RE: REVISED DRAINAGE PLAN FOR AN ADDITION TO SUNSHINE SHELTER  
(L-15/D39) ENGINEER'S STAMP DATED OCTOBER 25, 1991

PROJECT TITLE: ADDITION TO SUNSHINE SHELTER ZONE ATLAS/DRAINAGE FILE # L-15

RE: DRAINAGE PLAN FOR AN ADDITION TO SUNSHINE SHELTER  
(L-15/D39) RECEIVED OCTOBER 7, 1991

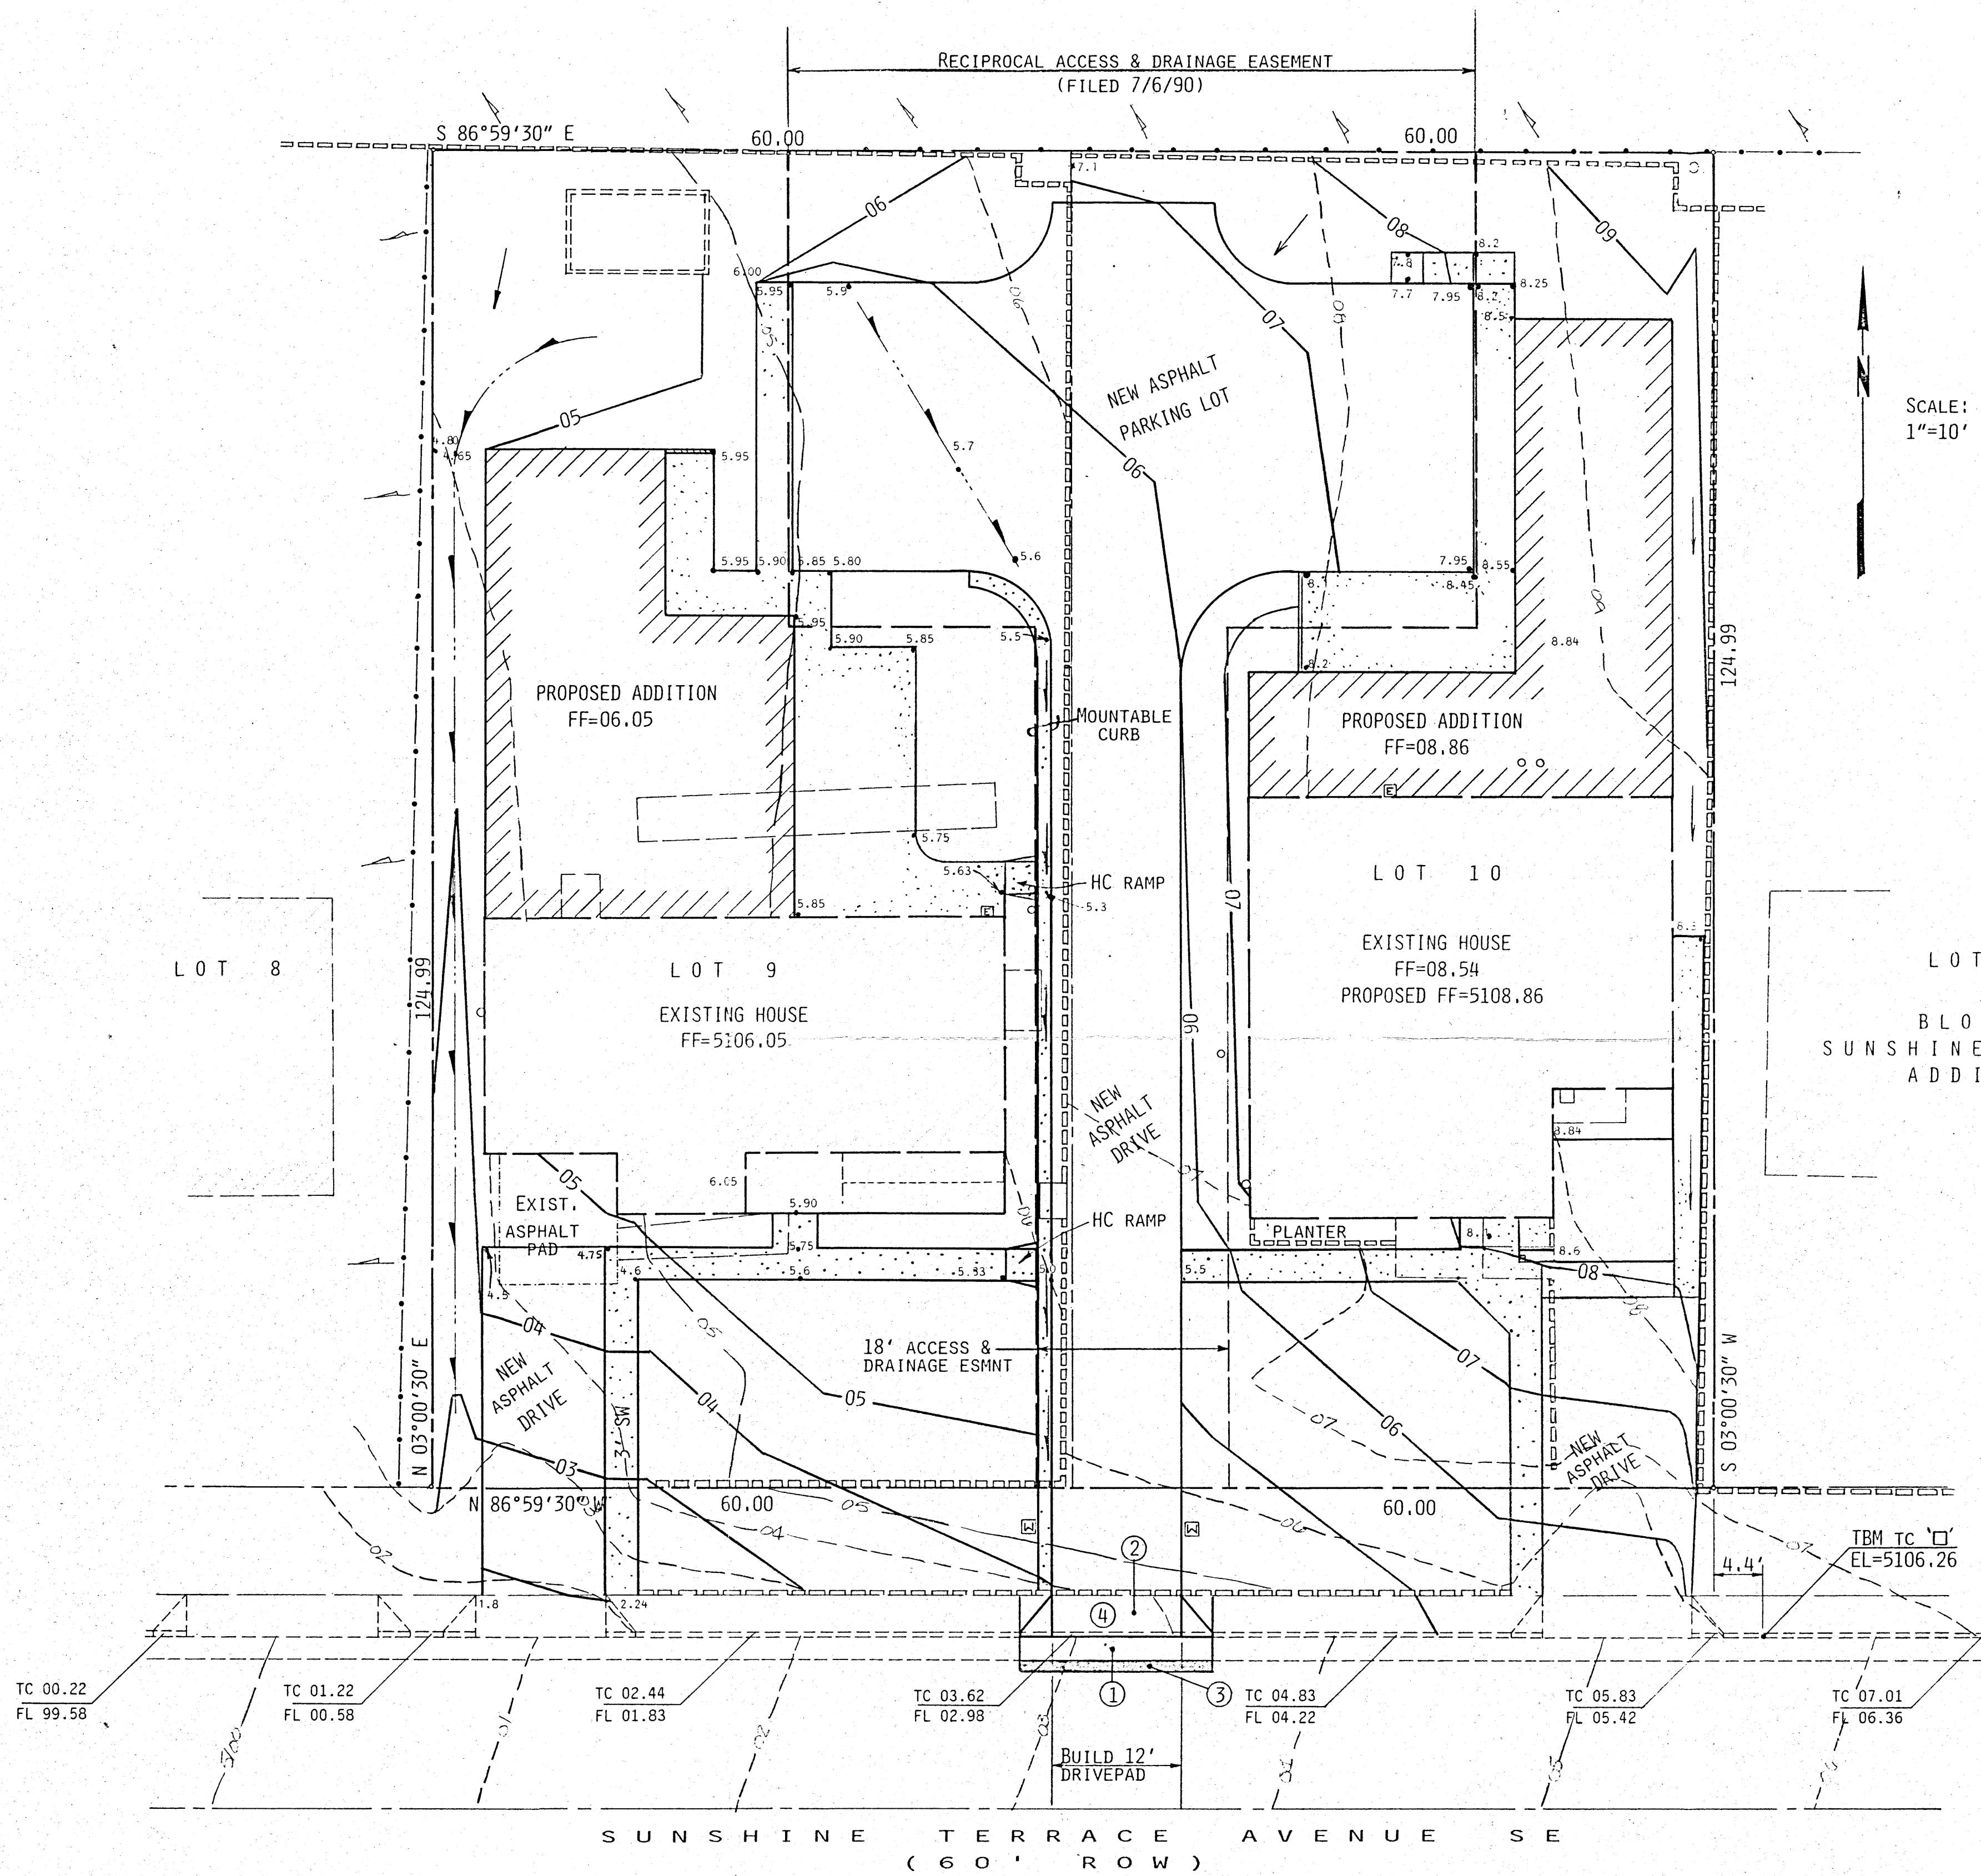
- ✓ 1. Finish Floor Elevations to full mean sea level designation.
- ✓ 2. Location and direction of roof drains.
- ✓ 3. Copy of plat showing the access and drainage easements.
- ✓ 4. Detail of proposed swale along the west property line of Lot 9 and east property line of Lot 10.
- ✓ 5. On Lot 10 you indicate your flow arrows from the proposed addition abutting a concrete slab. How do you propose to get the runoff over the slab and onto the asphalt.
- ✓ 6. The developed runoff from Lot 9 along the west boundary must be routed through the drive pad and not over the public sidewalk.
